Objection to Application 2025/91887 – Plot 1, Lingards Fold

I wish to formally object to the proposed changes under application 2025/91887 for Plot 1 at Lingards Fold.

title:
Proposed North + South Elevations
drawing status: Planning drawn by: JD checked by: JD
drawing no.: 2510-PL-01-200 rev: -

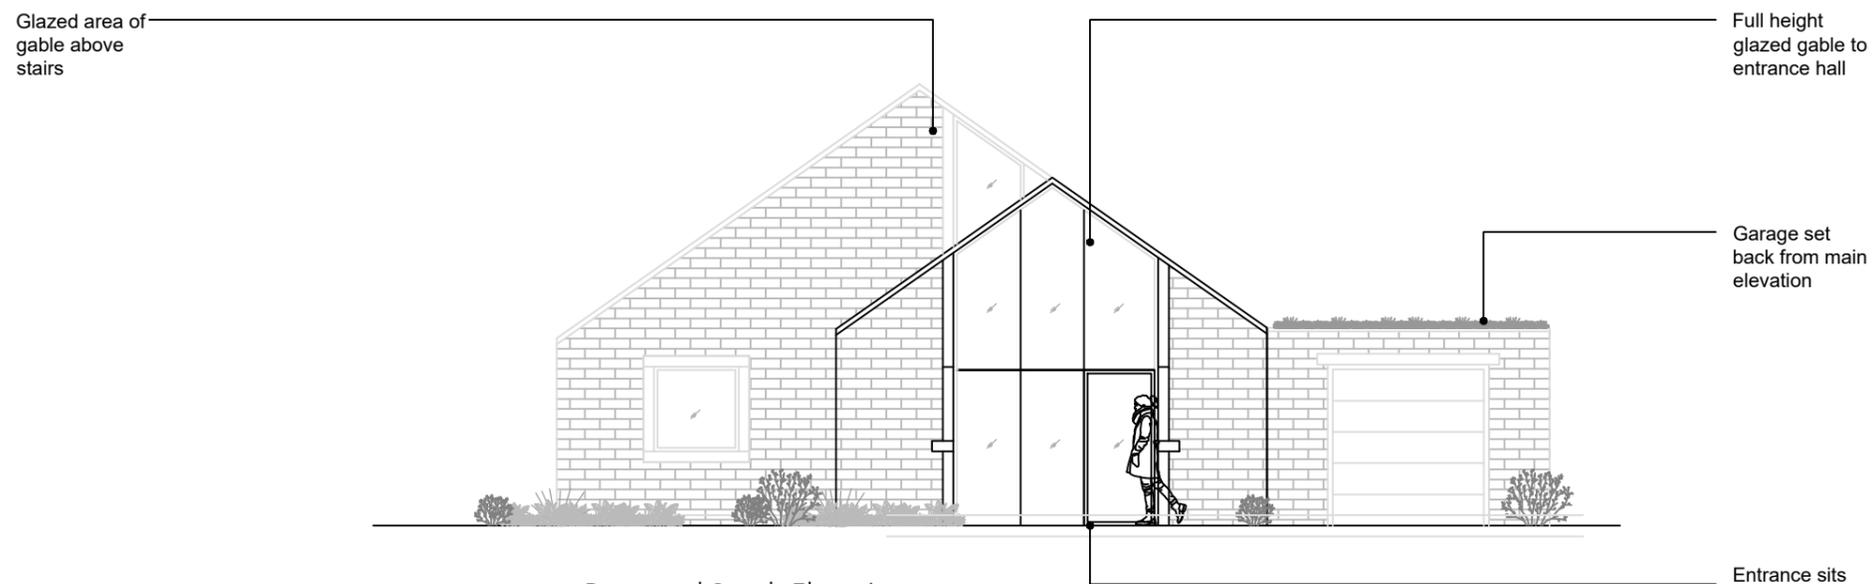
Plot 1 sits directly adjacent to the green belt. As such, it carries a heightened expectation of restraint, sensitivity, and visual harmony. The proposed increase in glazing, massing, and height is not in keeping with what a dwelling in this location should present. The rear elevation, in particular, introduces expansive glass panels, multi-level volumes, and urbanised features that are visually dominant and out of character with the surrounding landscape.

While sandstone remains the proposed material, the form and architectural tone have shifted dramatically. The building now reads less as a domestic dwelling and more as a high-spec urban structure—complete with garage integration, balcony space, and layered massing. This is not a minor revision; it is a redefinition of the plot's visual and spatial impact.
